The Planning Inspectorate

Our Ref: EN010139

Planning Act 2008 (as amended) – Section 89; and The Infrastructure Planning (Examination Procedure) Rules 2010 (as amended) – Rule 9

Procedural Decisions following additional submissions made by the Applicant and request for further information

Drawing Title  
**Street Works, Public Rights of Way & Access Plans Key Plan  
 APFP Regulation 5(2)(k)**

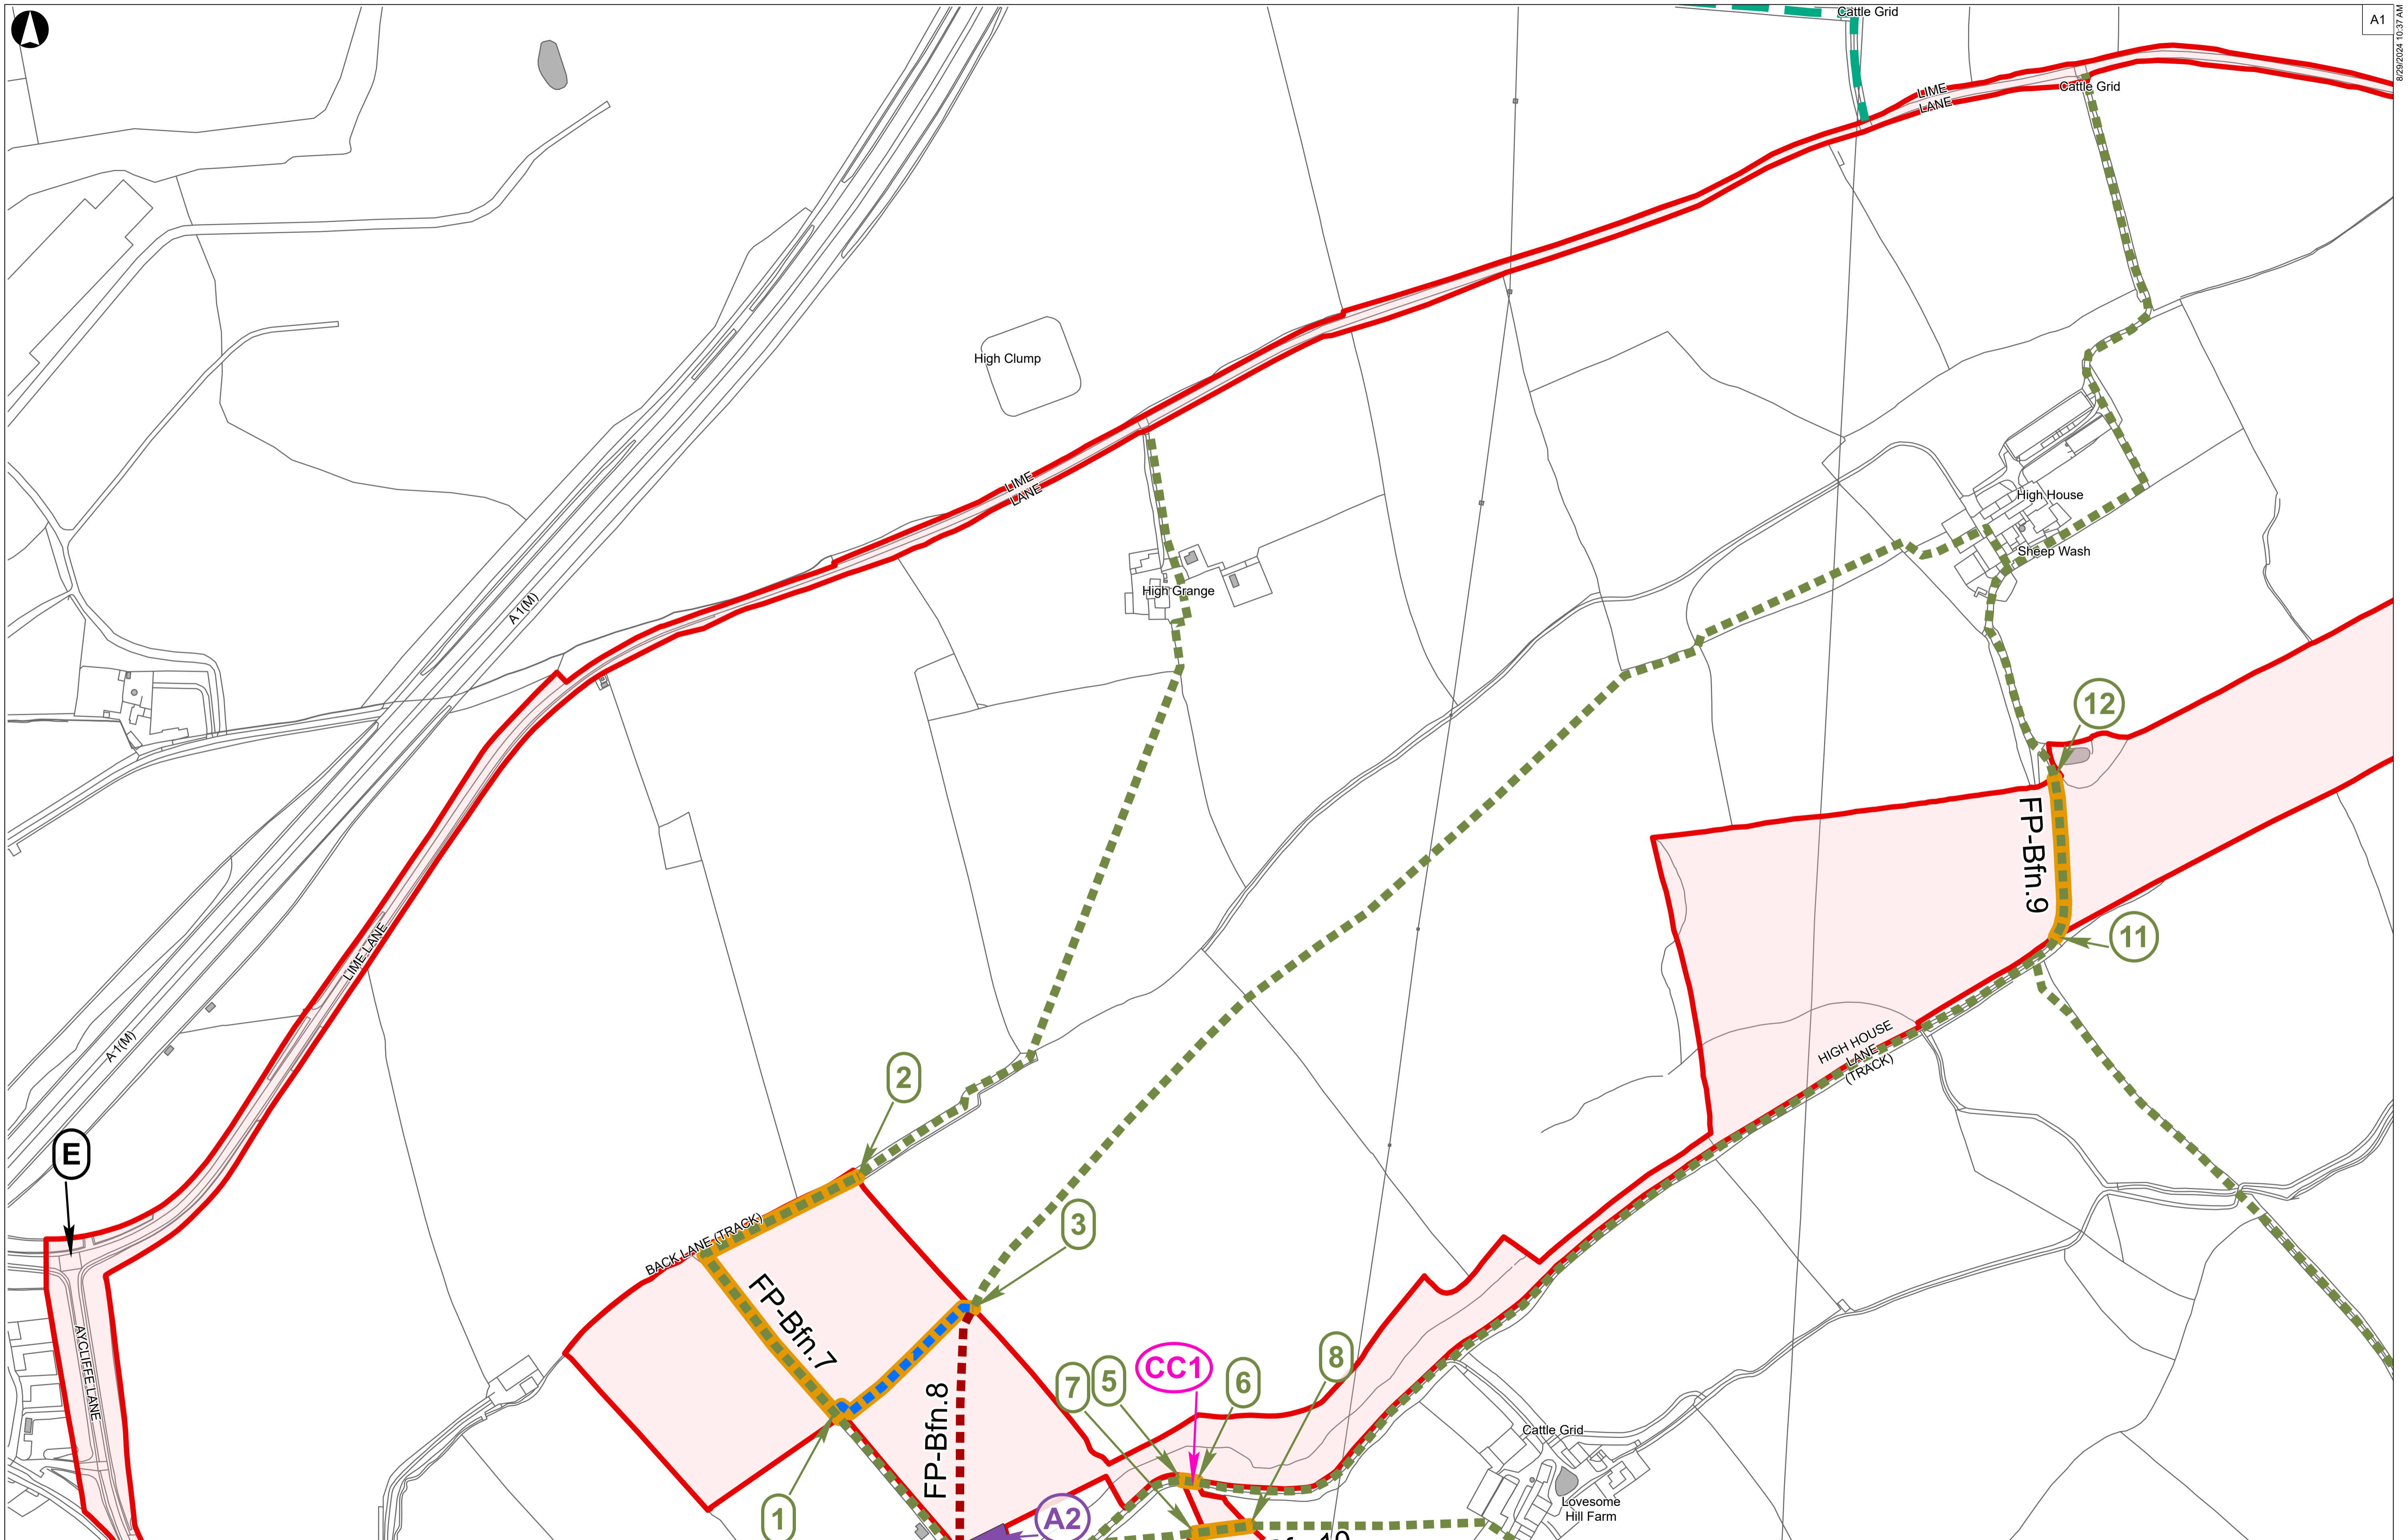
- provide further explanation on how these are accurately and clearly reflected in the current Land Plans [\[APP-010\]](#) and the Street Works, Rights of Way and Access Plans [\[AS-002\]](#);

- if the definition of "width of highway" in Sch. 3 and "highway" in Art. 9 do differ, then the Applicant is asked to clarify how this distinction has been reflected in the Land Plans [\[APP-010\]](#) and the Street Works, Rights of Way and Access Plans [\[AS-002\]](#) and how both plans clearly demonstrate the exact boundaries of the "width of highway";
